TfNSW reference: REN 26/00008/001, SF 2026/008717

Your reference: SSD-38358962

SSD-38358962, Keri Keri Wind Farm, Sturt Highway, Keri Keri; Response to Submissions

This attachment relates to TfNSW's response dated 11 March 2026 reference REN 26/00008/001.

Figure 12 - Murray Valley Highway onto Sturt Highway

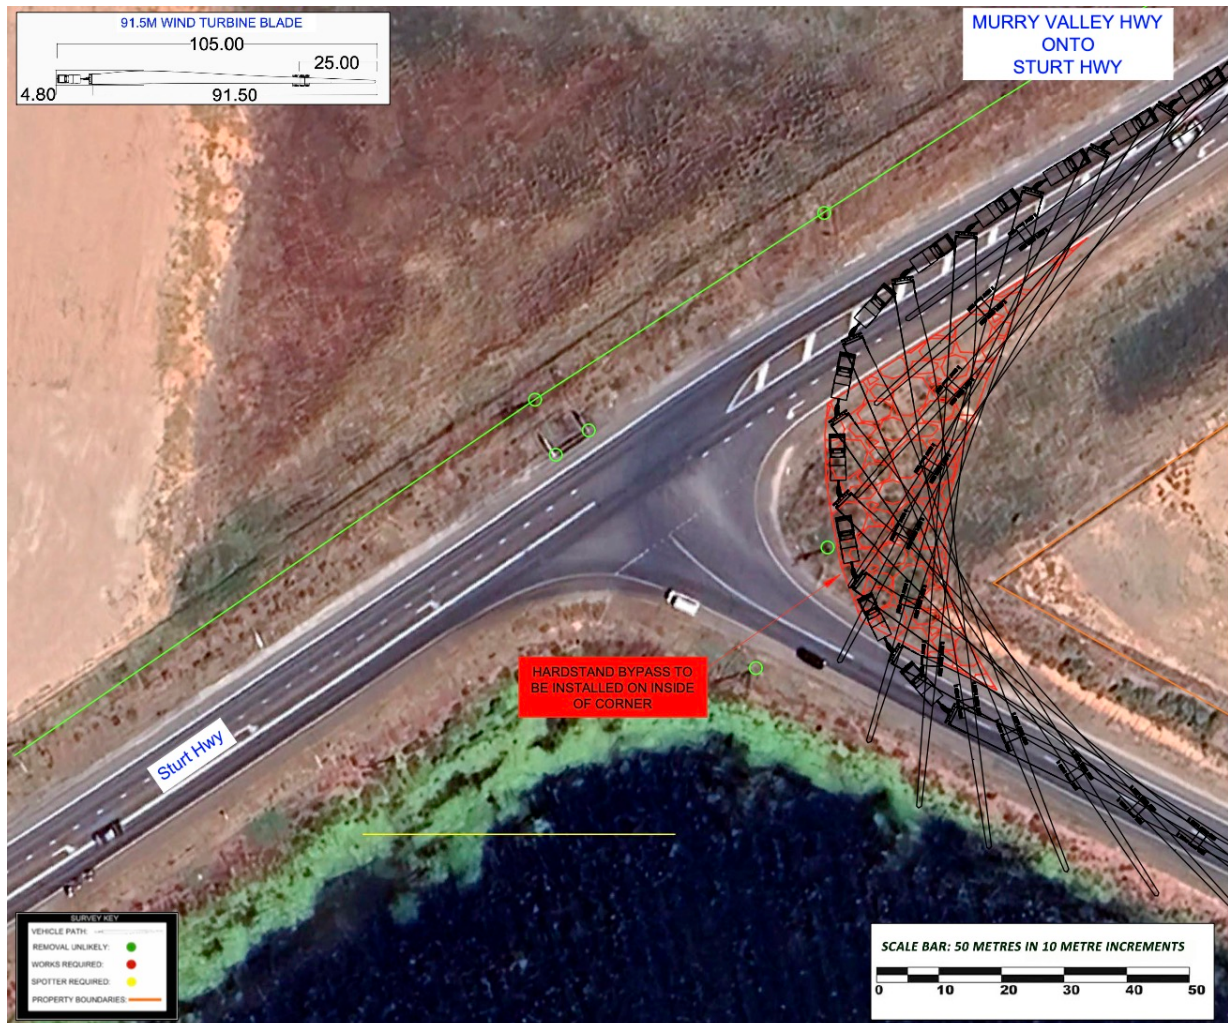
- a. Revision D civil Design, RJ Andrews SPA - Murray Valley Hwy onto Sturt Highway - The existing fill embankment is high, with swept paths showing to track close to cadastre boundaries. Hardstand areas will need to be quantified to determine the scope and footprint of the fill required for the embankment and to confirm whether land acquisition is required.

- b. Revision D Civil Design, RJ Andrews SPA - Murray Valley Hwy onto Sturt Highway - There appear to be numerous underground utilities located on the south-east corner of the intersection. Further investigation required to determine the level of impact.

Figure 16 - Sturt Highway onto Keri Keri Road

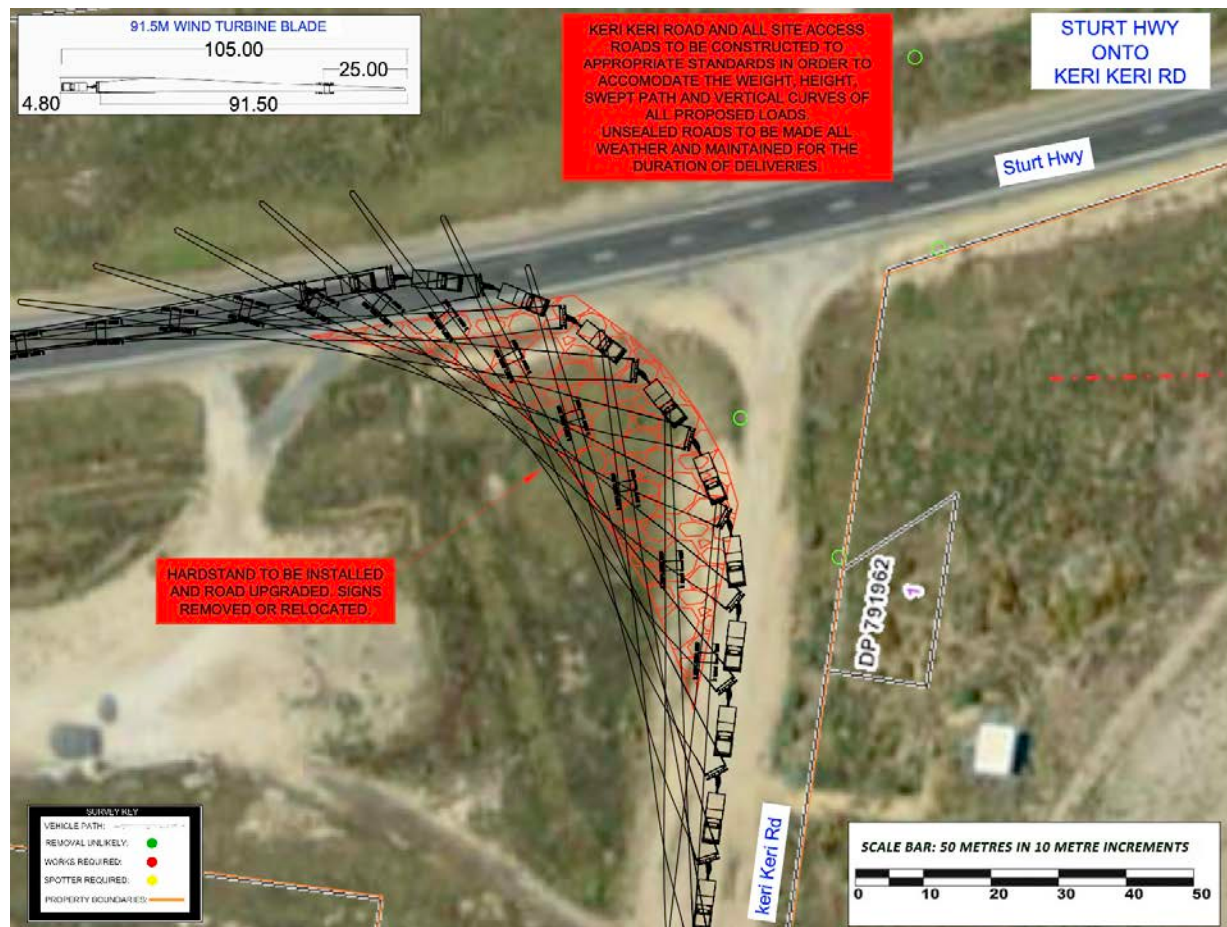
- f. Revision D, Civil Design RJ Andrews SPA - Keri Keri Road intersection - A hardstand strategic concept design will be required prior to determination to confirm the impacts on the Sturt Highway and how it will interact with Keri Keri Road. How will the hardstand be managed to reduce the likelihood that light vehicles will use the hardstand daily?

Figure 17 - Sturt Highway into site entrance

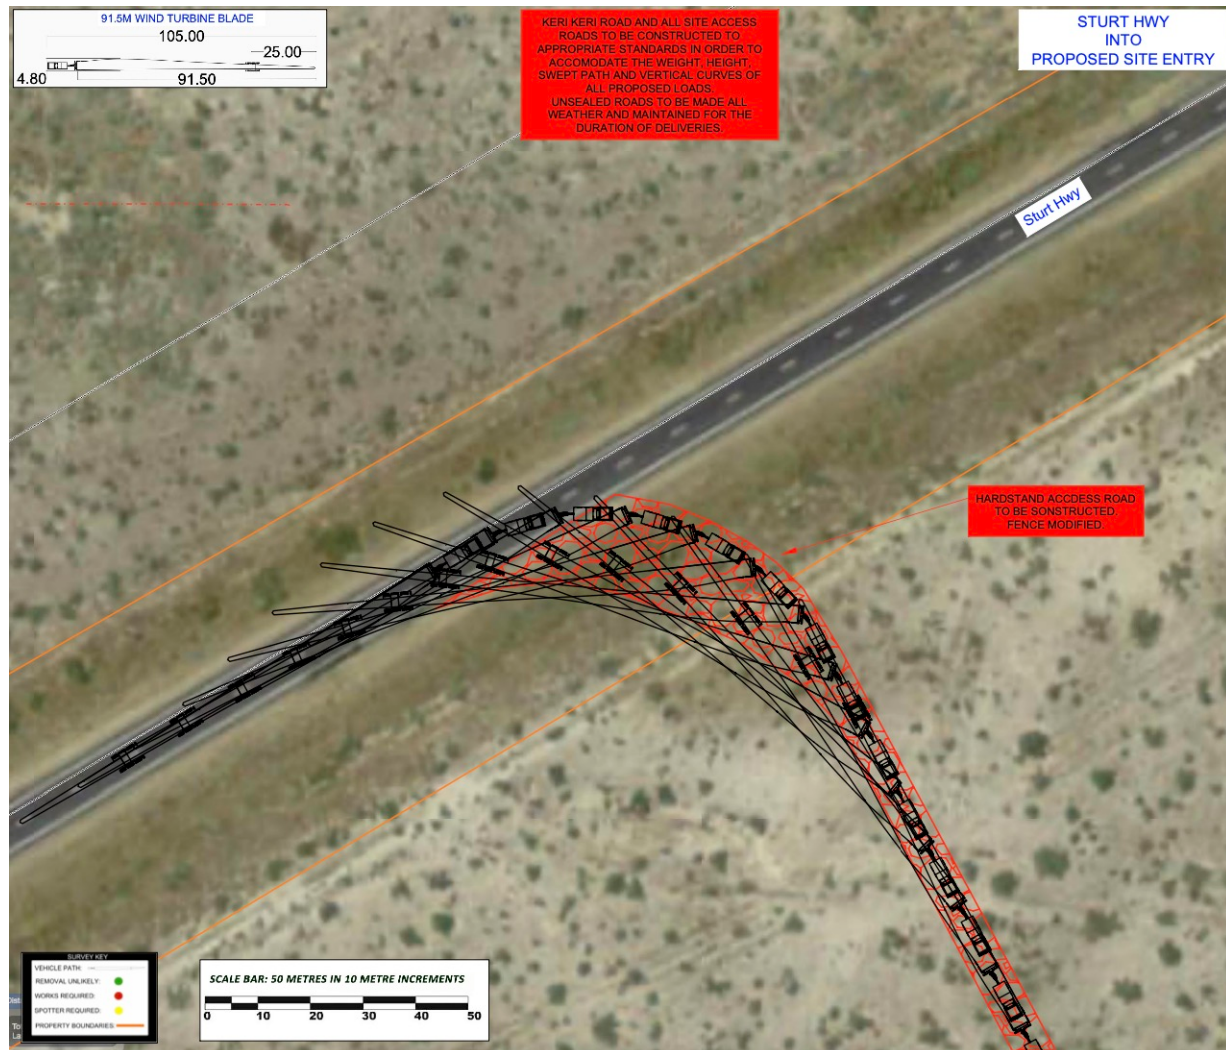
- d. Drainage pits will need to be assessed and made trafficable as required. To be annotated on the strategic concept designs.
- e. Revision D, Civil Design RJ Andrews SPA - Keri Keri Northern Site Entrance - A swept path analysis has been provided. A strategic concept design of this intersection will be required prior to determination to confirm the impacts on the Sturt Highway.
